## WEST SUSSEX COUNTY COUNCIL CONSULTATION

| <b>FROM:</b>                    | WSCC - Highways Authority                                                                                                                                                                                                                                                                                             |
| <b>LOCATION:</b>                | Land North of Hook Lane<br>Hook Lane<br>Pagham                                                                                                                                                                                                                                                                        |
| <b>SUBJECT:</b>                 | P/79/21/RES<br><br>Approval of reserved matters following P/30/19/OUT for 300 No. new homes, internal roads, footpaths & cycleways, car parking & landscaping (resubmission of P/132/20/RES). This application affects the setting of a listed building & falls within Strategic Site H SP2, CIL Zone 1 (Zero Rated). |

Project **Hook Lane, Pagham**
Drawing **Site Layout**

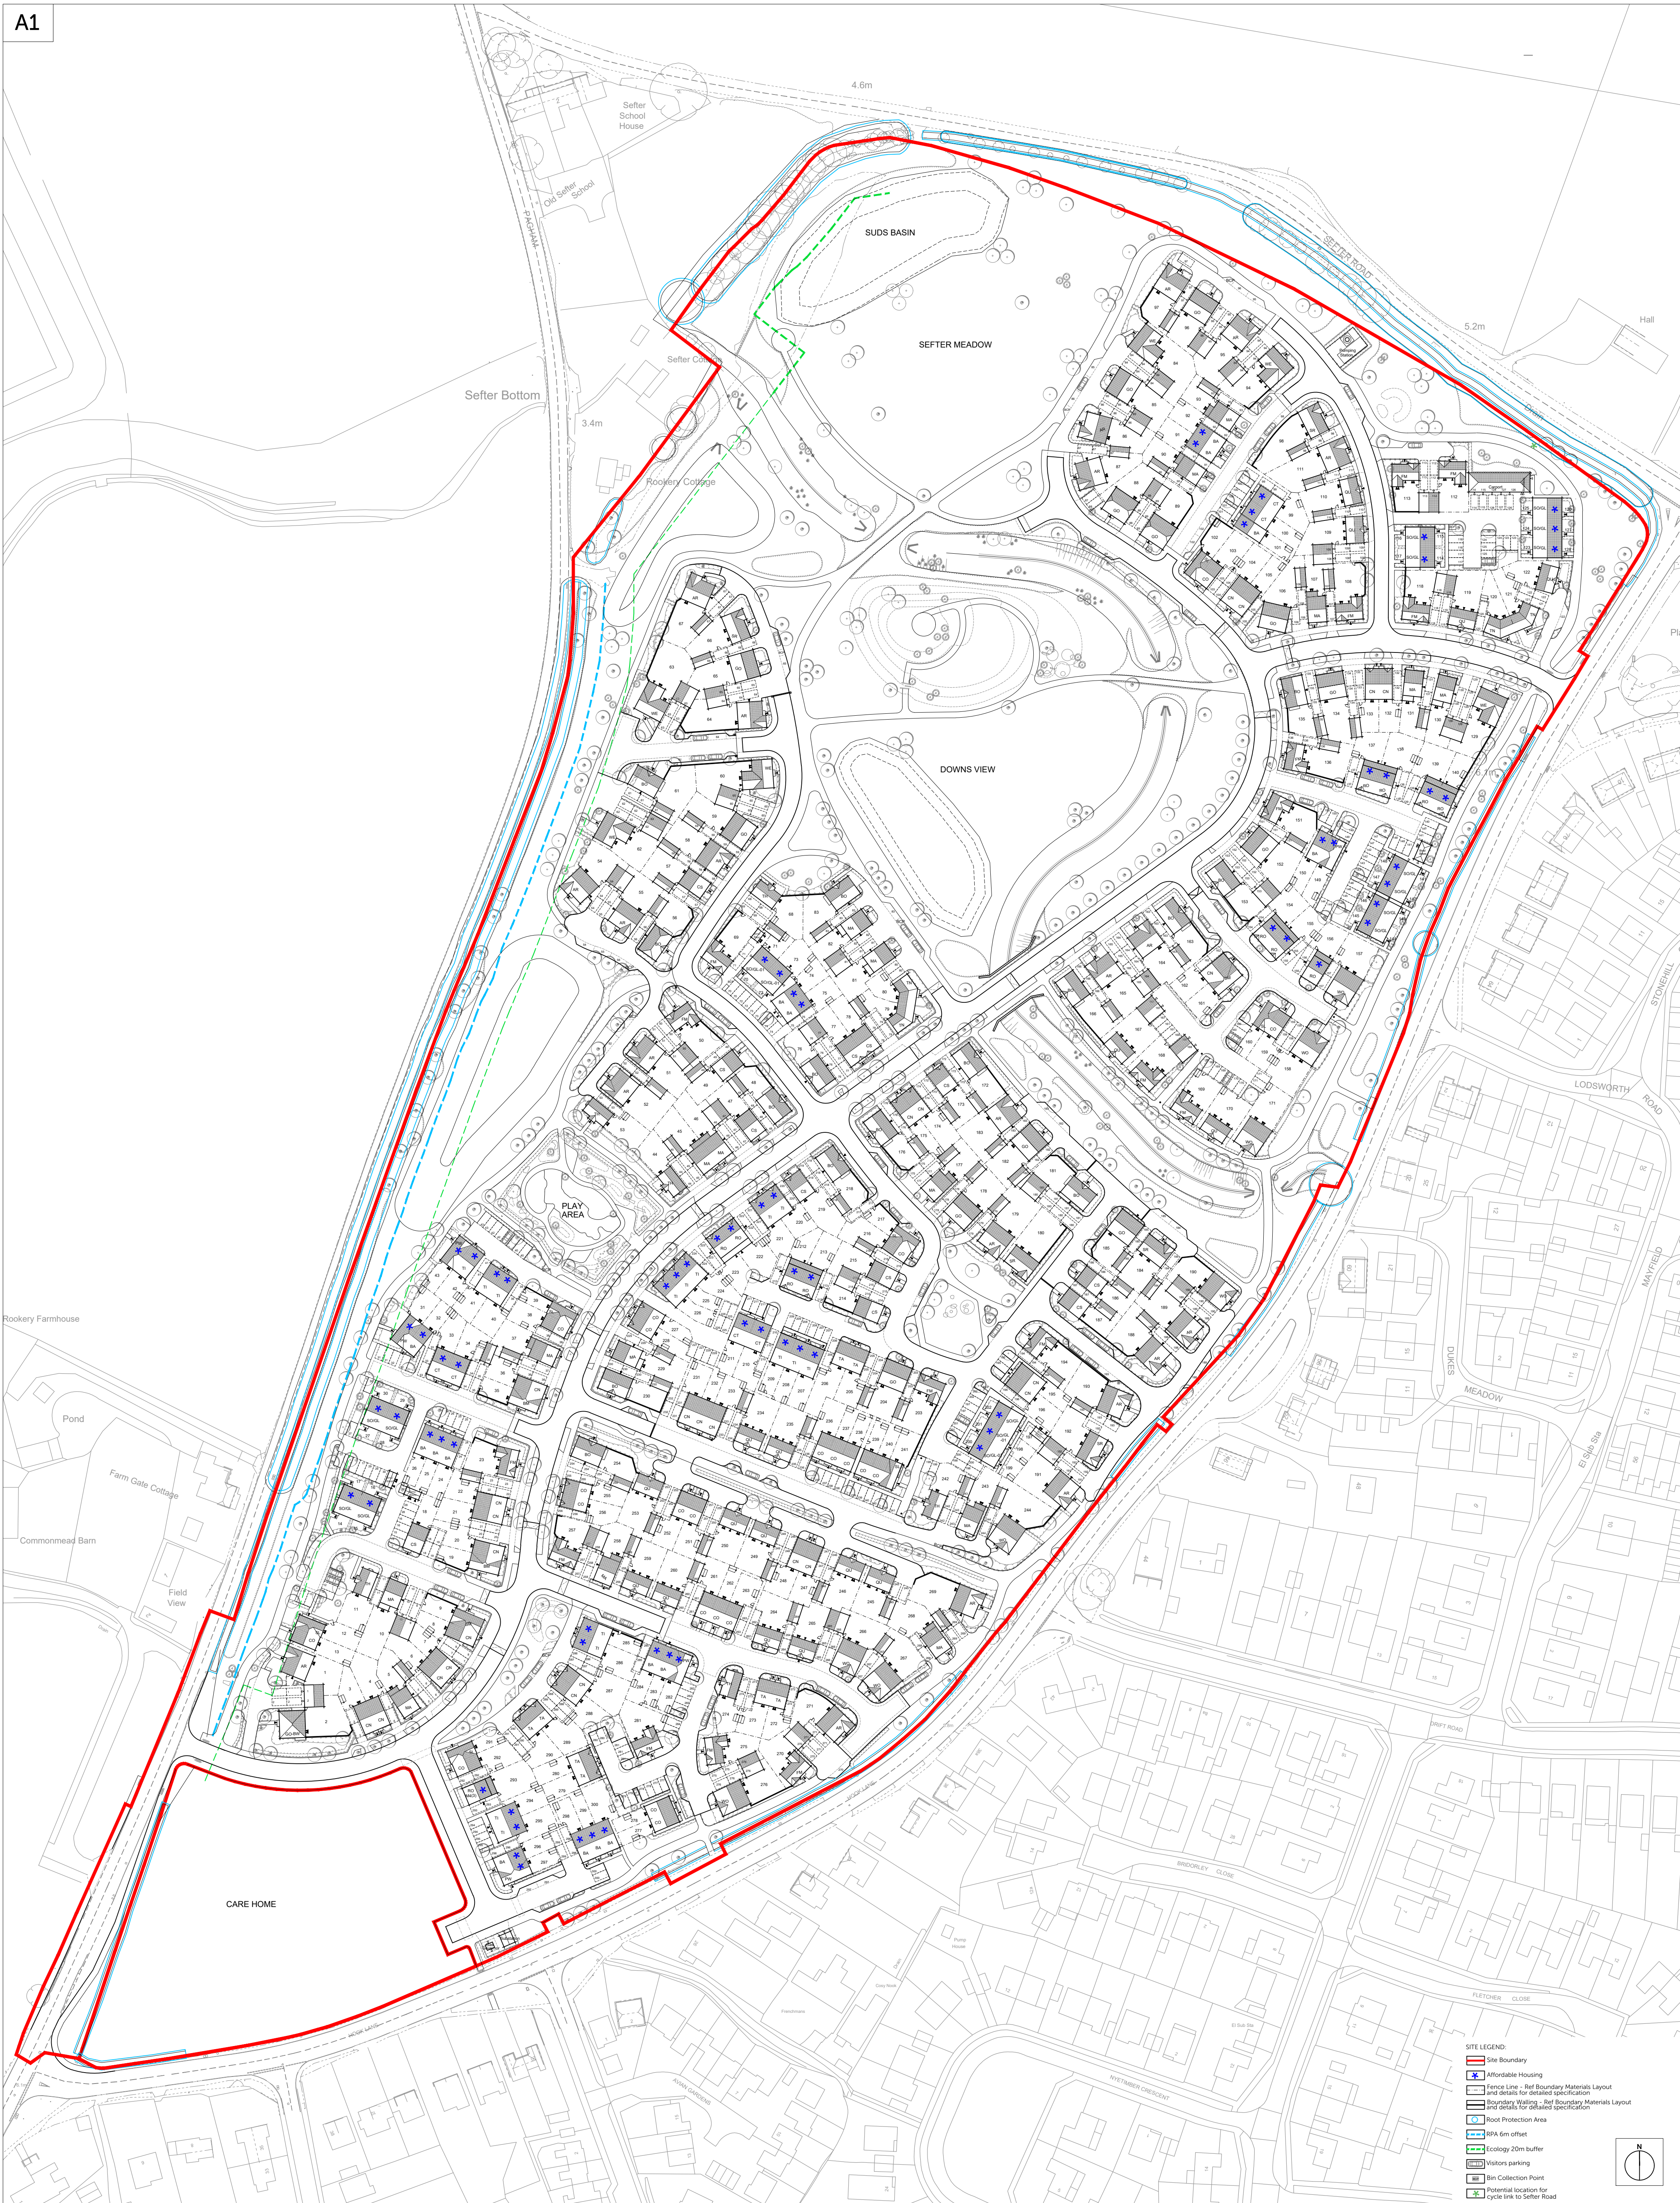
6. There are a number of comments regarding detailed aspects of the layout,
7. The parking layby opposite plots 234-235 is unusual given it creates an isolated carriageway narrowing with no other comparable features anywhere else within the development. The layby should be inset into the foot/cycleway, the need for which is question in point 16 below.

11. Although unclear at this stage what the intention is regarding highway adoption, the applicant should note that allocated parking cannot be provided within the adoptable highway. This is mentioned as the Site Layout drawing indicates a number of lay-by spaces being allocated to specific properties.

13. The various drawings show a cycle route around the perimeter of the site. This is as per the approved Design Code. Whilst the route is shown within the Design Code, there are aspects to this where changes would make for a better arrangement than presently indicated. On the Site Layout Northern drawing, the cycle route runs southwards and requires cyclists to join the carriageway opposite plot 59. Cyclists then rejoin the cycle route opposite plot 50/51. It's acknowledged that the carriageways that will need to be used by cyclists will be lightly trafficked. It's unclear however why the cycle route is not being routed past plots 67 southwards to plot 54, and then rejoining the existing facility opposite plot 50. This would then provide a continuous off highway route, which is far more preferable to the arrangement shown. It is accepted that this change would not necessarily be in accordance with the approved Design Code.

16. The need for the cycle route running on the southern side of the access road from plot 244 to 230 is questioned. At plot 230, cyclists are required to join the carriageway. From that point, the only option is to use the carriageway. The length of access road between plot 244 and 230 will be relatively lightly trafficked, and as such cyclists could join the carriageway near plot 244 and make use of the carriageway. This point is further reinforced as those properties on the north side of the carriageway (i.e. plots 231-244) have no footway requiring pedestrians to walk within the carriageway.

17. The arrangement of the route running on the west side of the access road between plots 292-297 must be revised. The route as shown is neither convenient or direct. The access road serves a small number of dwellings and as such cyclists can use the carriageway with opportunities to join the cycle way provided adjacent to plot 292 and 297. This would make for a far more direct and practical arrangement than shown.

18. The footway requirement on the eastern side of the open space labelled 'Downs View' would also be questioned. There is no frontage development on the eastern side of this area of open space. As such, the provision of this length of footway is perhaps unnecessary and could be removed.
